Response to Transport for NSW Letter dated 16 December 2019

Development Application No: SSD-7308 Description of Development: St Marys Freight Hub Property Description: Lot 2 Forrester Road, Lots 3 Lee Holm Road and Lot 196 Christie Street, St Marys

Figure 3: Proposed signage and access point widening for St Marys Freight Hub (Source: BG&E)

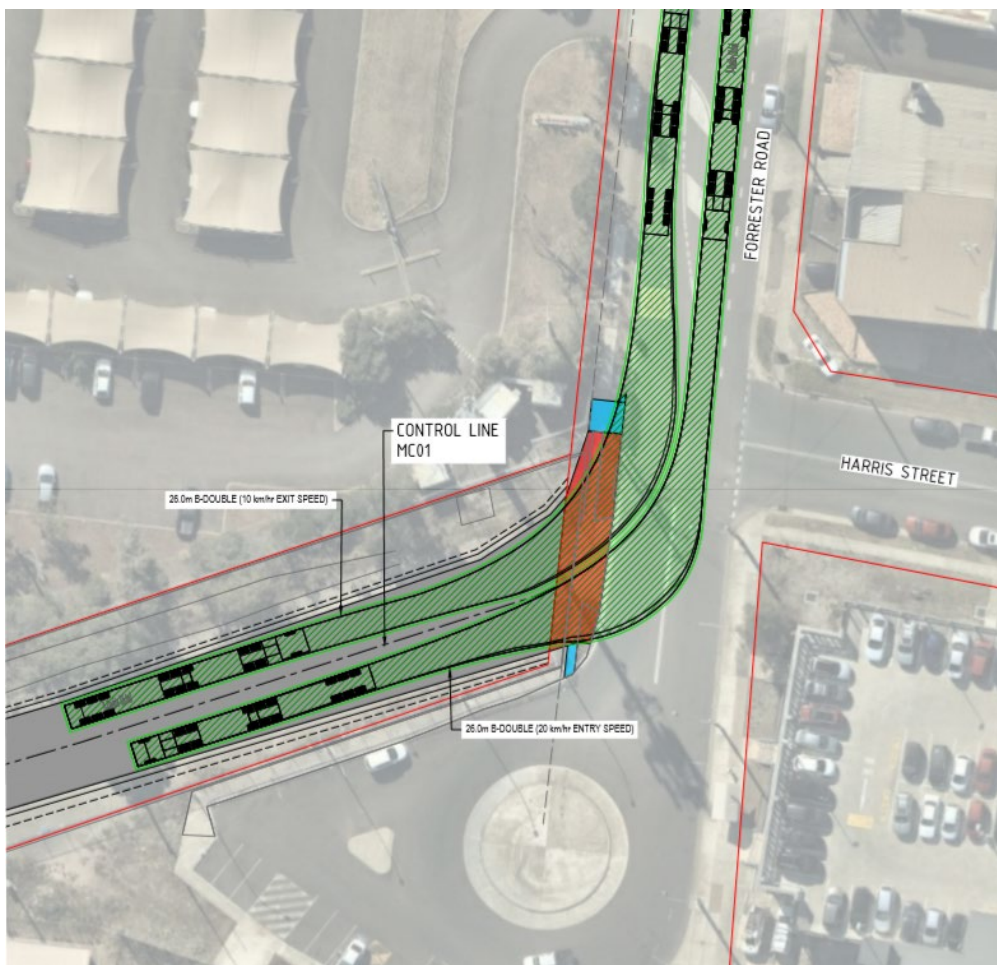
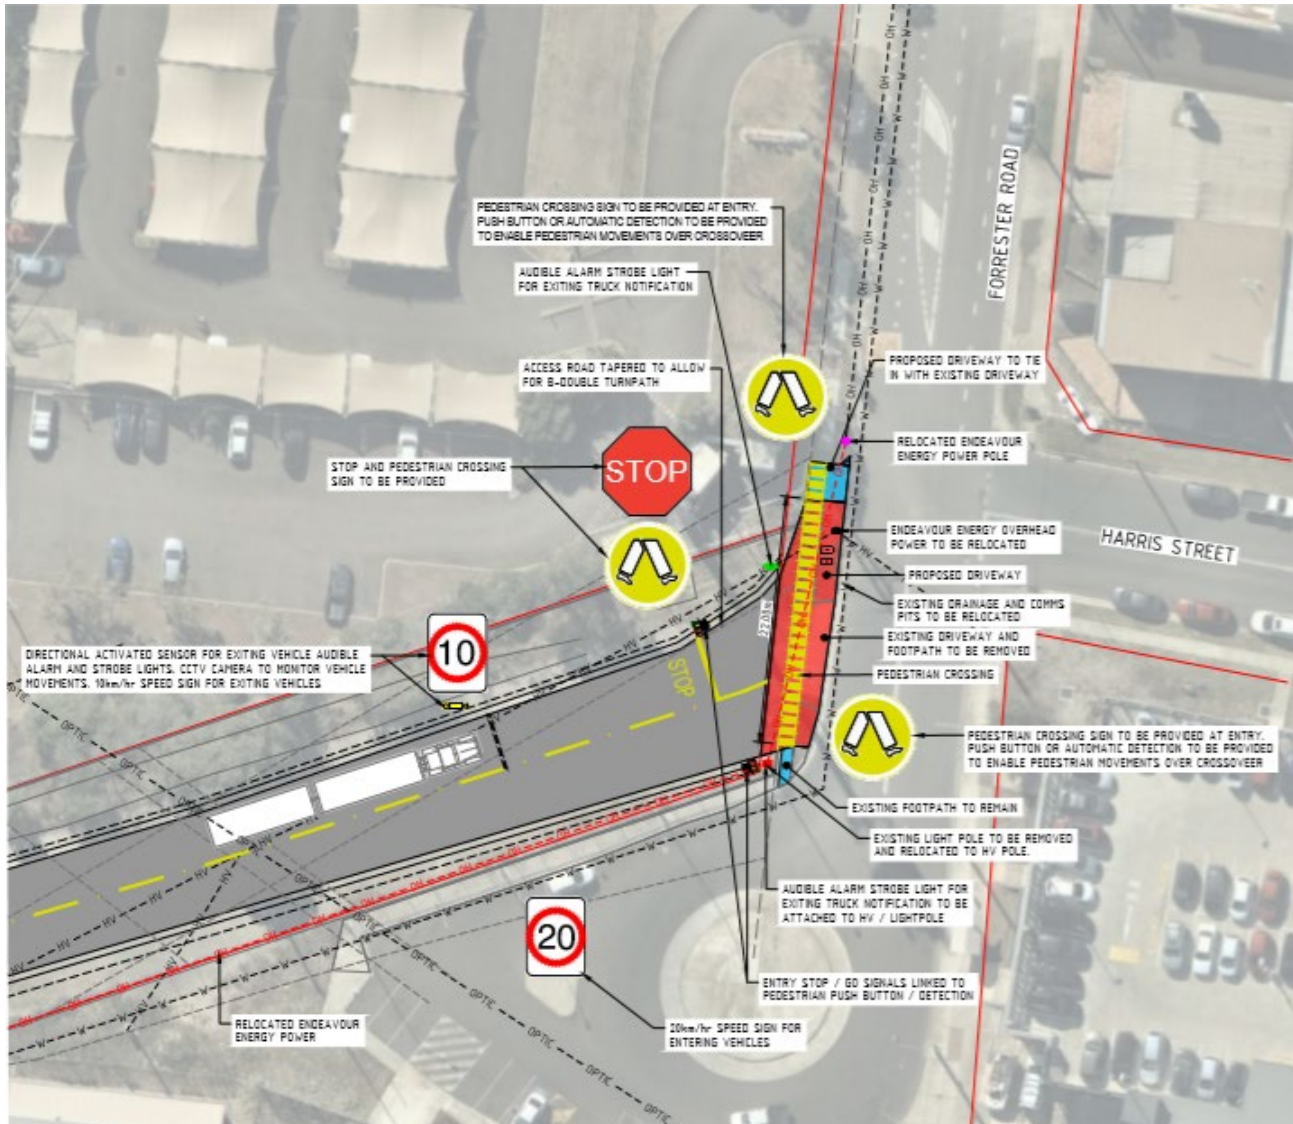
B-double entry/exit	<ul style="list-style-type: none"> The proposed access on Forrester Road will extend into the adjoining property frontage in order to achieve the simultaneous B double entry/exit. This cannot be supported at this stage, until evidence of consent from the adjoining property owner has been obtained. 	<ul style="list-style-type: none"> An alternative access crossover design has been prepared associated with Route Option 4 which does not require the crossover to extend beyond an extension of the property boundary. A Road Safety Audit has been completed including a safety response for the entry is in Part B – Road Safety Audit within the enclosed “St Marys Freight Hub Heavy Vehicle & Transport Analysis: Summary Report”.
